20 August 2020

**SSD 9249 Modification 5 - Project Area Adjustment and Members Facilities
Building Envelope; and,**

SSD 9835 Modification 2 - Stadium Members Facilities

Figure 1 - Stadium Fitness Facilities Proposed Location

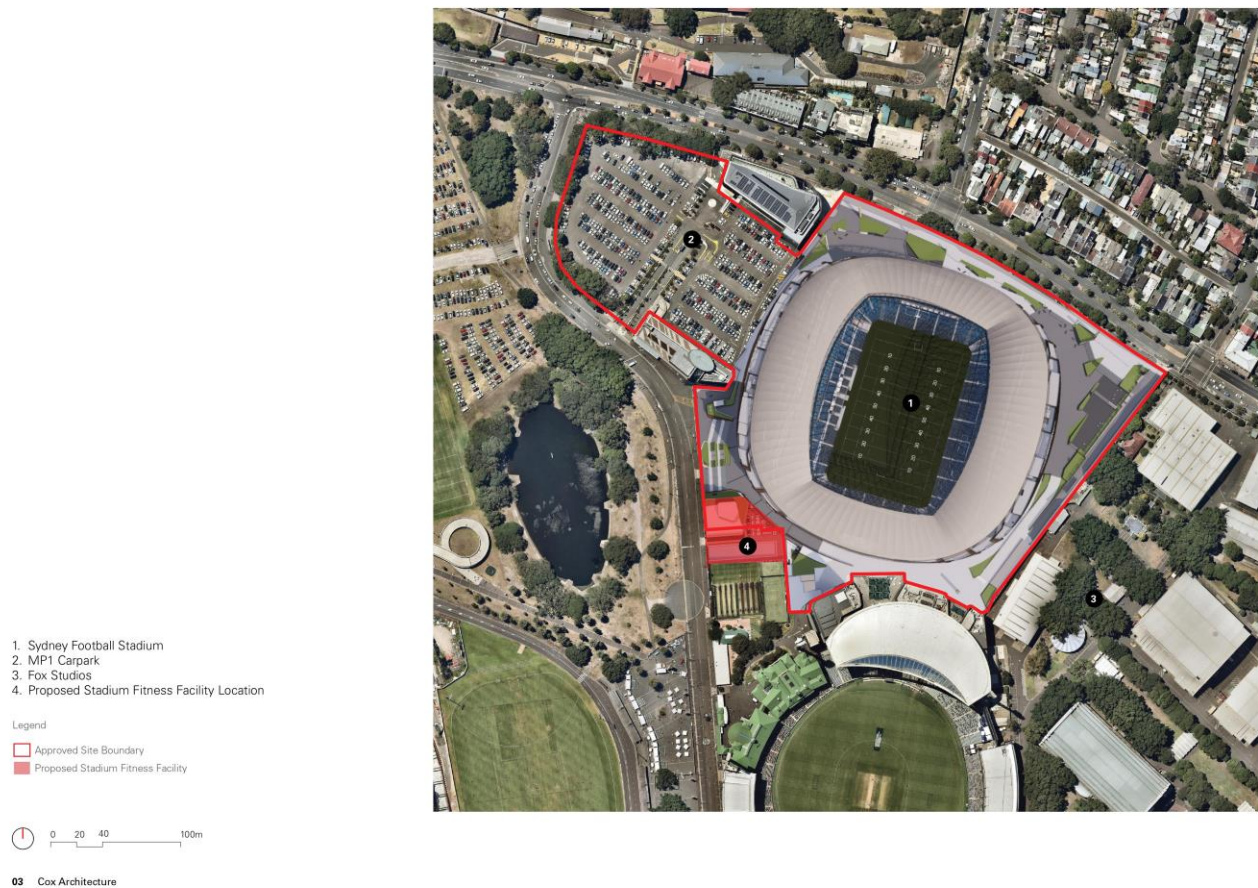
Although much of the proposed members facility will be out of sight behind the boundary wall and in the undercroft space beneath the main entry stairs to the stadium off Driver Avenue, a significant proportion of the building will still be visible above the wall.

However, from the street level it could read as a three-storey building. Its form and bulk would have an imposing presence on Driver Avenue in the immediate vicinity and diminish the strong definition of the boundary fence along Driver Avenue in this location.

Our view is that these impacts could be mitigated by modifying the upper levels of the proposed Members Facility, so the mass of the building is shifted back closer to the stadium and its surrounding concourse to achieve a more sympathetic visual transition from the stadium to the boundary fence.
